**Moriah College Redevelopment (SSD 10352)
Response to Submissions**

Thank you for your correspondence via Major Projects Planning portal (ref: PAE-8349545) on 16 July 2020, requesting Transport for NSW (TfNSW) to review the subject matter. Legislation came into effect on the 1 December 2019 that brings the former Roads & Maritime Services and Transport for NSW together into an integrated organisation. This response represents the collective views of the integrated organisation.

Figure 4.7: Proposed Concept Design of Baronga Avenue Pedestrian Crossing Extension

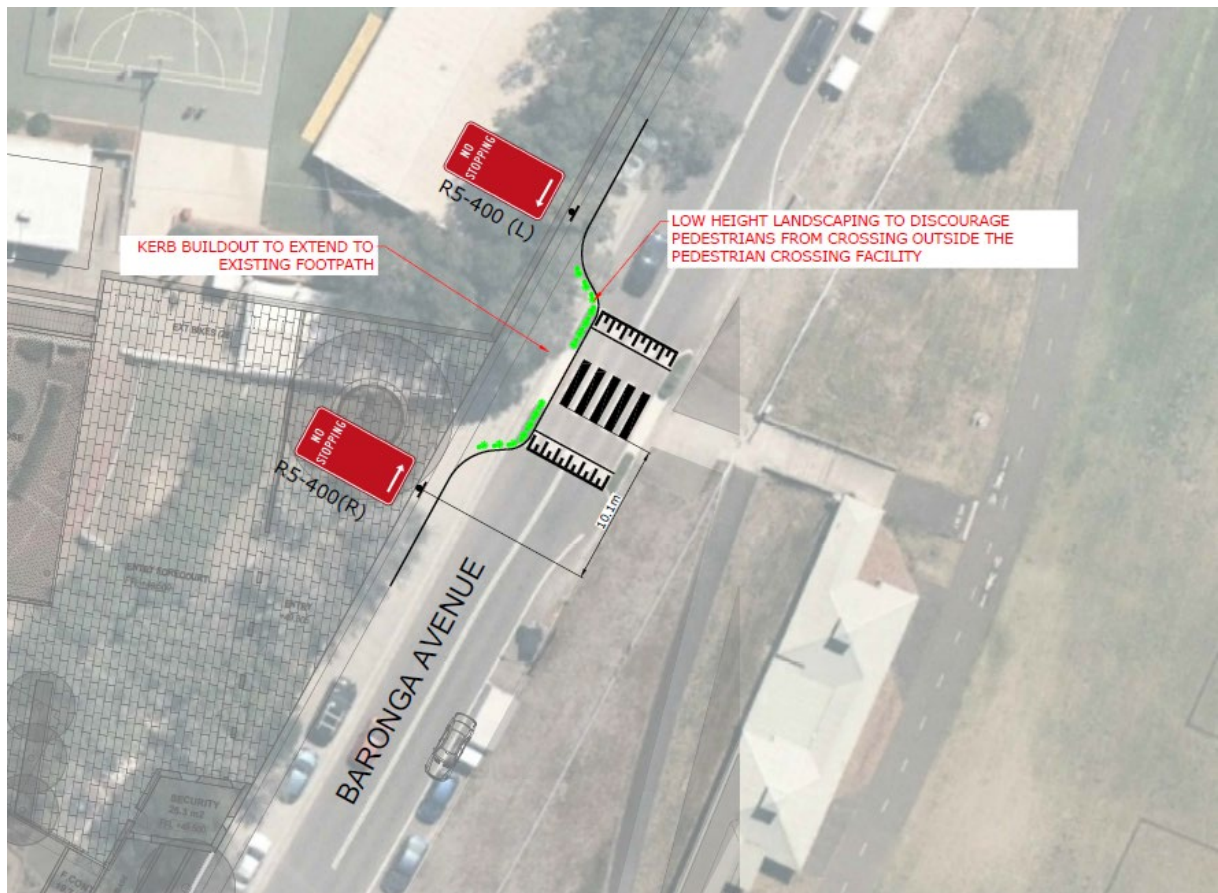
Prior to the issue of a construction certificate, a Road Safety Audit (RSA) shall be undertaken by an independent TfNSW accredited road safety auditor for the proposed improvement of the existing pedestrian crossing on Baronga Avenue. The applicant shall implement safety measures as proposed by the RSA.
